SweetWater CUP		
Agency	Comment	Response
WA State Dept. of Health, Russel Mau		
1	No water provided (via well etc.) No further comments.	Agreed. Project is described with catering requiring water etc. to be brought in for events. If and when water is obtained or transferred the appropriate processes will be followed.
KVFR		
1	Fire Flow Plan: approved by KVFR in terms of access and connections.	On site mtg with KC Fire Marshall on 5-24-21, who reviewed access and conditioned the project to the following regarding Access: <b>1.</b> Add 2ft of gravel to the driveway which will make it 20ft wide. <b>2.</b> Entrance is sufficient no need for a 2nd ingress and egress.
2	Facility subject to a 15+minute response time	OK
3	Fire alarm and sprinklers are recommended irrespective of code requirements., This will significantly offset on site water storage and fire flow requirements	On site mtg with KC Fire Marshall on 5-24-21, who reviewed access and conditioned the project to the following regarding: <b>1.</b> The building calculation regarding occupancy load was below the requirement of 300 therefore sprinklers and water storage are not required. <b>2.</b> A draft fire hydrant is required at

Revised Site Plan
 Submittal Date
 6-11-21

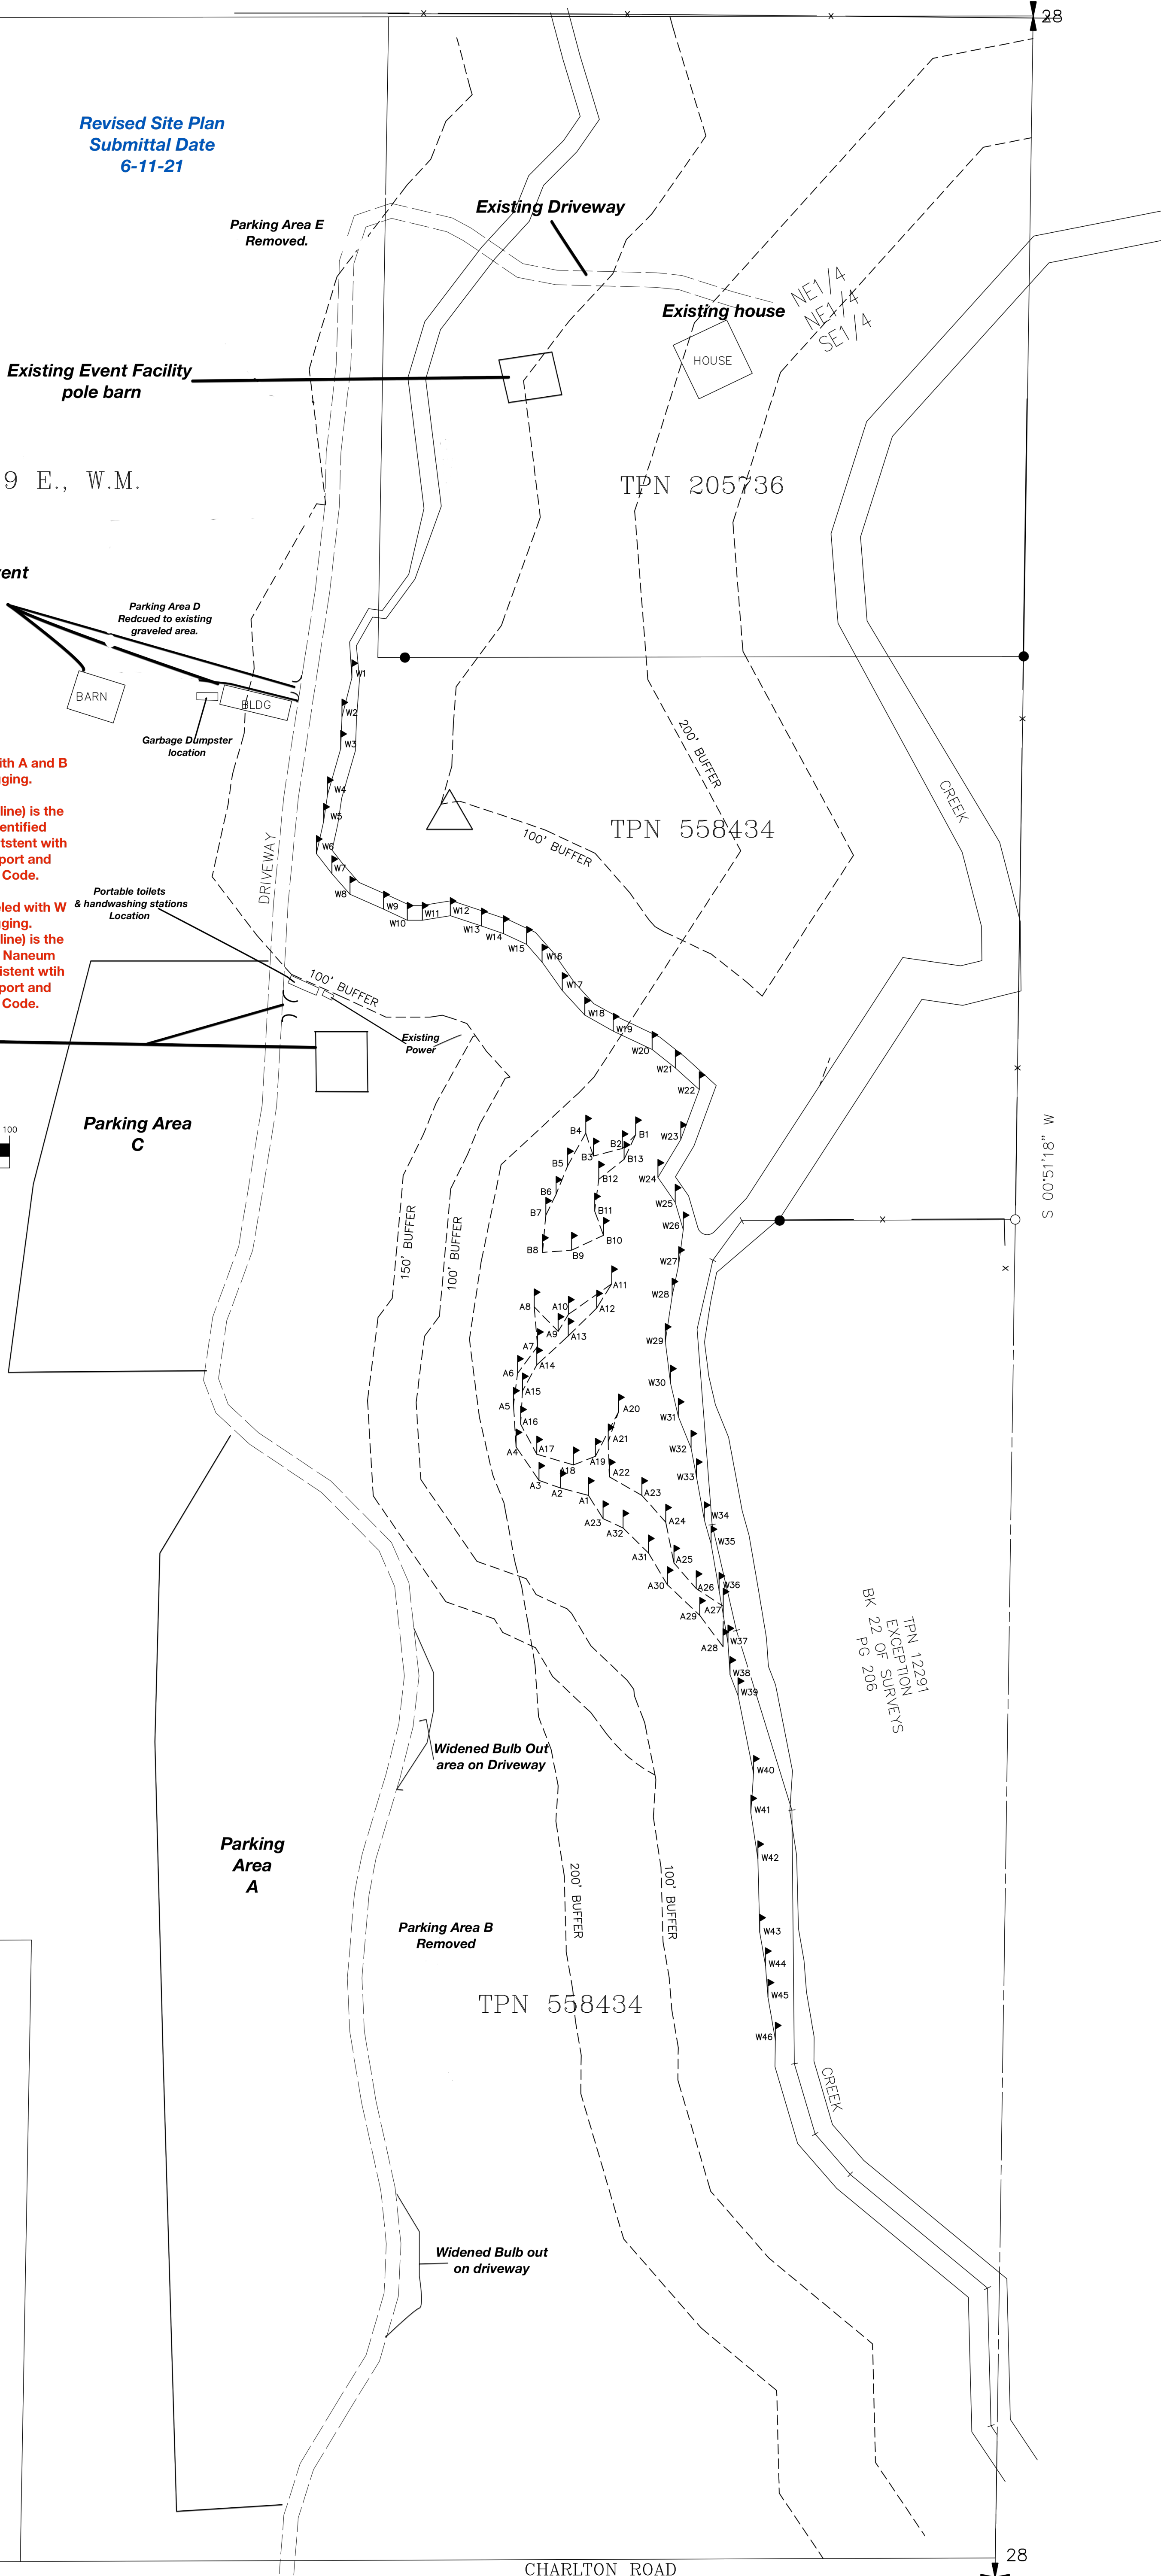
9	Parking Area D is within the shrubsteppe habitat	Parking Area D will not be enlarged as depicted on the site plan. There will be no parking on shrubsteppe habitat within this parking area. With that said there is an existing graveled parking area associated with the existing structures at this location that will continue to be used for those existing structures etc.

10	Parking Area E is within the shrubsteppe habitat	Applicant agrees to remove Parking Area E.
11	Potentially Parking Area C (depending upon the extent) could be within the Shrubsteppe habitat.	Parking Area C is within existing irrigated pasture ground and contains no shrub steppe habitat.
12	From Aerial imagery, there appears to be a drainage with some riparian vegetation that would be impacted. It's stated that this is in irrigation ditch, yet no assessment of current habitat quality or function of that area is described.	The Critical Areas report was completed and identified these irrigation ditches. These ditches convey water to the subject property and to other adjacent properties pertinent to their water rights. Therefore there is no need for an assessment on of these ditches. These ditches within this area have had ongoing maintenance and repair making it more aesthetically pleasing while still providing better conveyance of water to the adjacent landowner.

13	WDFW would like understand the impacts of this drainage for F&W habitat.	The Critical Areas report was completed and identified these irrigation ditches. These ditches convey water to the subject property and to other adjacent properties to the south pertinent to the senior irrigation water rights. Therefore there is no need for an assessment on of these ditches. In fact the existing underground irrigation line has been improved that provides water to the pasture ground around the venue and other surrounding areas.
14	Parking Area B is next a well vegetated area which is identified as an irrigating ditch. WDFW would like understand the connection of that ditch to Naneum Creek.	The Critical Areas report was completed and identified these irrigation ditches. These ditches convey water to the subject property and to other adjacent properties pertinent to their water rights. Therefore there is no need for an assessment on of these ditches. More important and after further review the applicant proposes to remove Parking Area B.

15	WDFW request that these parking areas either be configured to avoid these habitat impacts, or habitat mitigation proposed (such as enhancement of other habitat areas on the property to offset these impacts.	See above changes pertinent to parking areas.
16	WDFW would like to meet on site with the applicant and KCCDS to further discuss the issue of minimization of habitat impacts and/or habitat mitigation.	Ok
17	WDFW request that proposed trails and fire wising extents be shown on the site plan to better understand the impacts and there be no net loss of function form the existing riparian area of Naneum Creek.	The applicant has a right to place trails within the pasture ground and grass area around the event facility or for that matter on their property.
18	If habitat impacts are expected, then habitat mitigation in the form of riparian enhancement in other areas of the riparian area to offset impacts are requested.	The existing structures are within existing pasture ground etc. These structures are outside of the required buffers that were established in the Critical Areas Report and consistent with Kittitas County's Critical Areas Code. Furthermore these existing structures are outside of the adopted shoreline boundary designation and all have been constructed under existing/approved building permits with Kittitas County. With the aforementioned, and since the existing structures are located in an existing pasture etc. mitigation will not be needed.
